My reference: 3/2026/0613
Direct Dial: (01200) 425111
www.ribblevalley.gov.uk
Email: planning@ribblevalley.gov.uk
Date: 24 September 2026

Location: Barn at Talbot Hotel 5 Talbot Street Chipping PR3 2QE
Proposal: Approval of details reserved by condition 3 (Details of rooflights) on planning permission 3/2025/0538 granted on appeal 6000878.

APPLICATION NO. 3/2026/0613

06 Rear Elevation
Scale 1:100

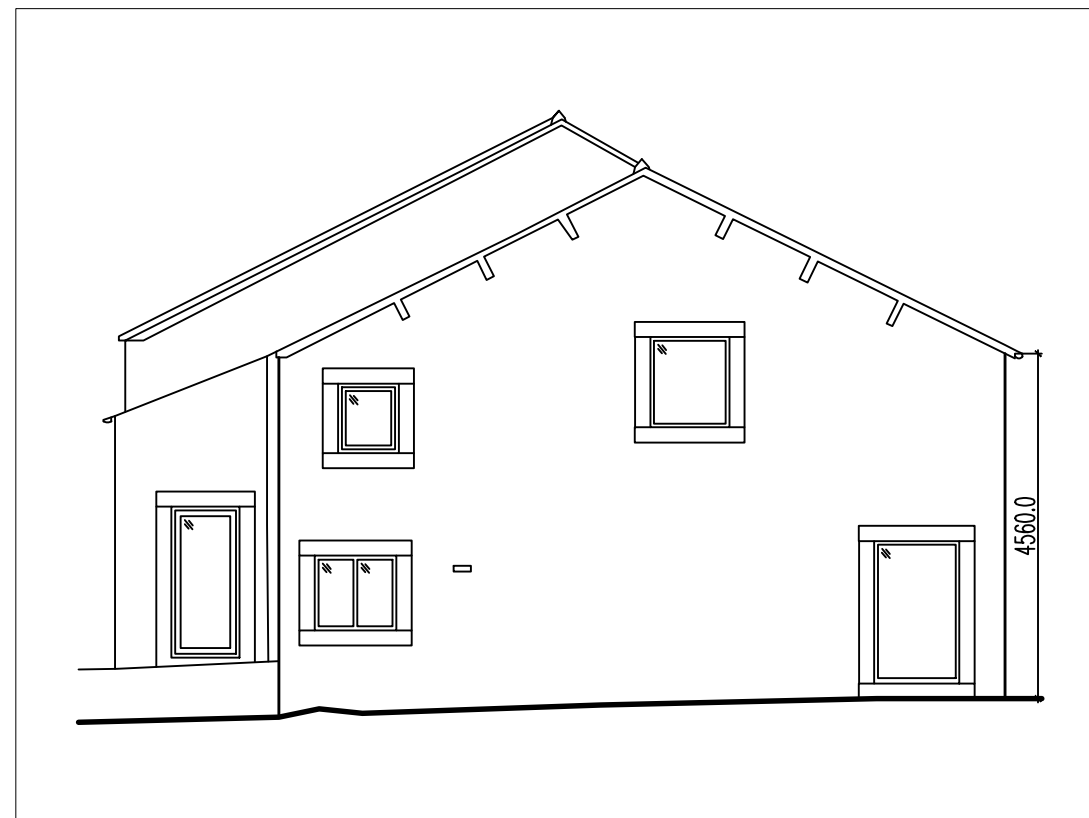
Condition 3 (Details of Rooflights) can be partially discharged in so far as the details shown on Proposed Velux's to Rear Elevation ZT23-196-41 A and product datasheet Velux Heritage Conservation roof window, GCL Glazing 01 size 550mm x 978mm are acceptable. In order to satisfy the condition in full the development shall thereafter be carried out in strict accordance with the approved details.
